October 8, 1992

RE: REVISED DRAINAGE PLAN FOR AN ADDITION TO HOME & COMMERCIAL SECURITY  
(G16-D105) ENGINEER'S STAMP DATED 9/17/92.

September 30, 1992

RE: DRAINAGE PLAN FOR AN ADDITION TO HOME & COMMERCIAL SECURITY  
(G16-D105) ENGINEER'S STAMP DATED 9/17/92.

DRAINAGE PLAN

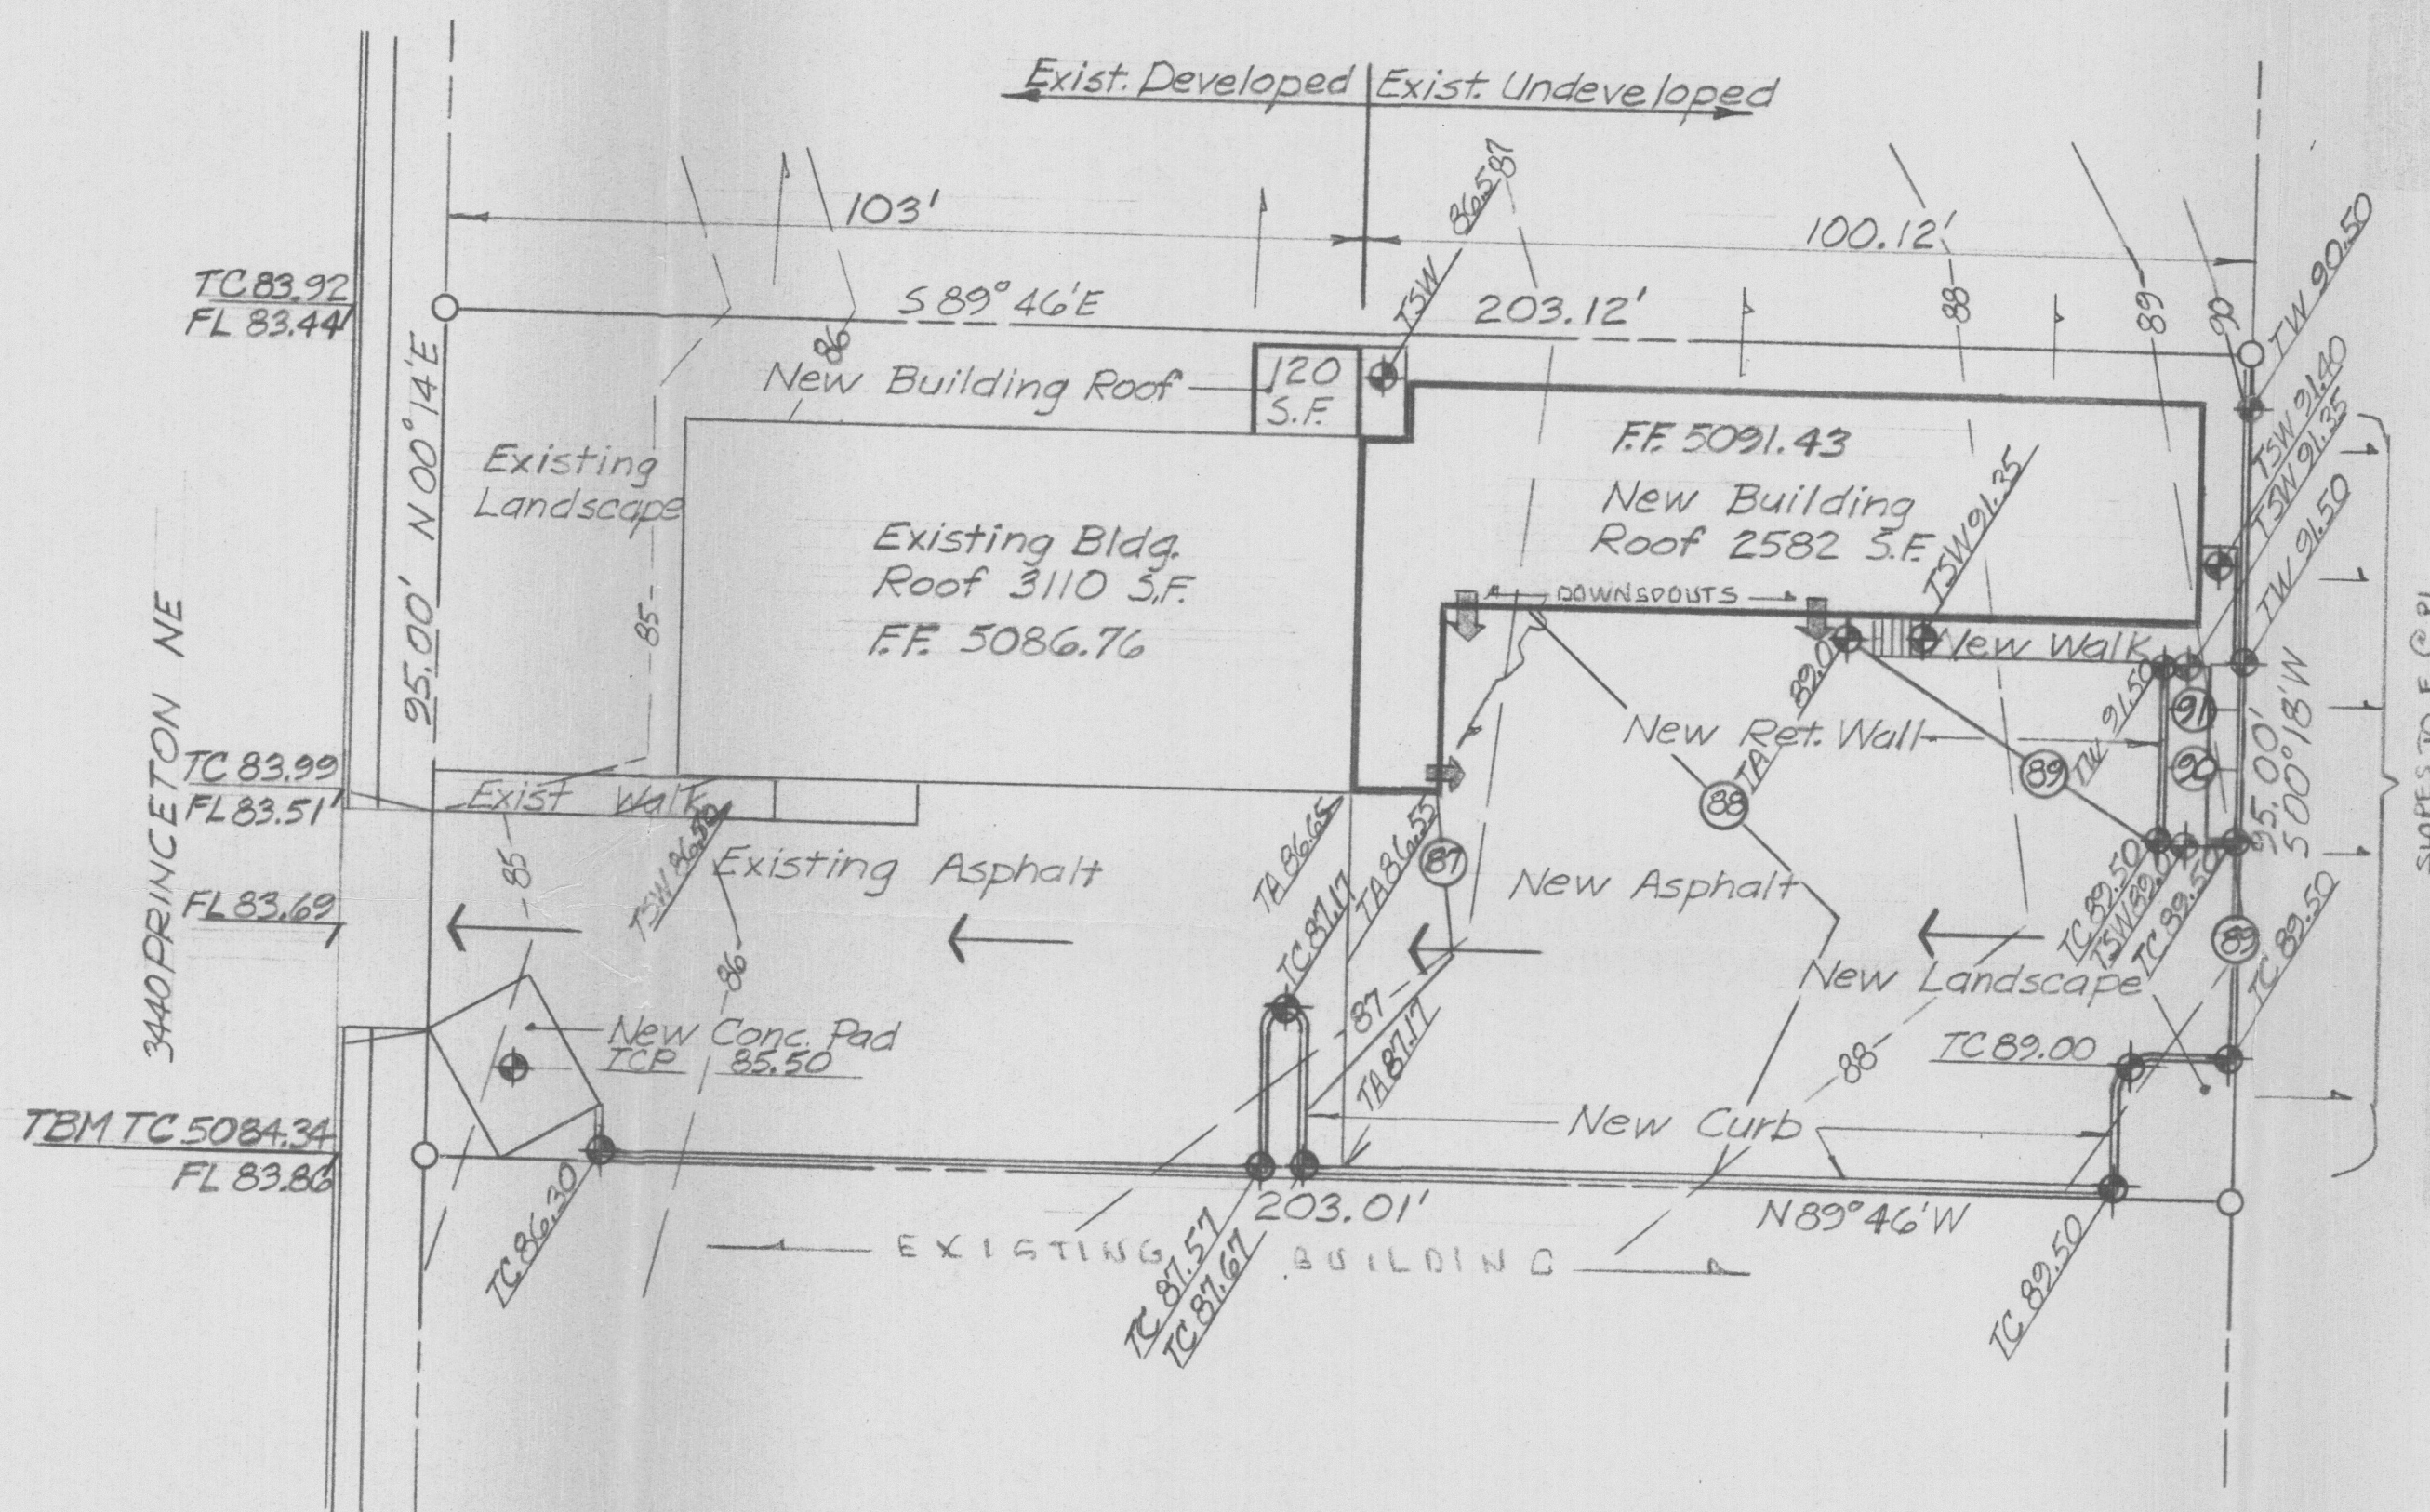
Based on the information provided on your September 21, 1992 submittal, listed you will find certain items which will need to be addressed prior to final approval:

- ✓ 1. Legal Description on the plan drawing.
- ✓ 2. Location and direction of proposed roof drains.
- ✓ 3. Location and description of ACS Datum used.
- ✓ 4. Contours indicate you may have off-site flows entering the site from the East. Please address.
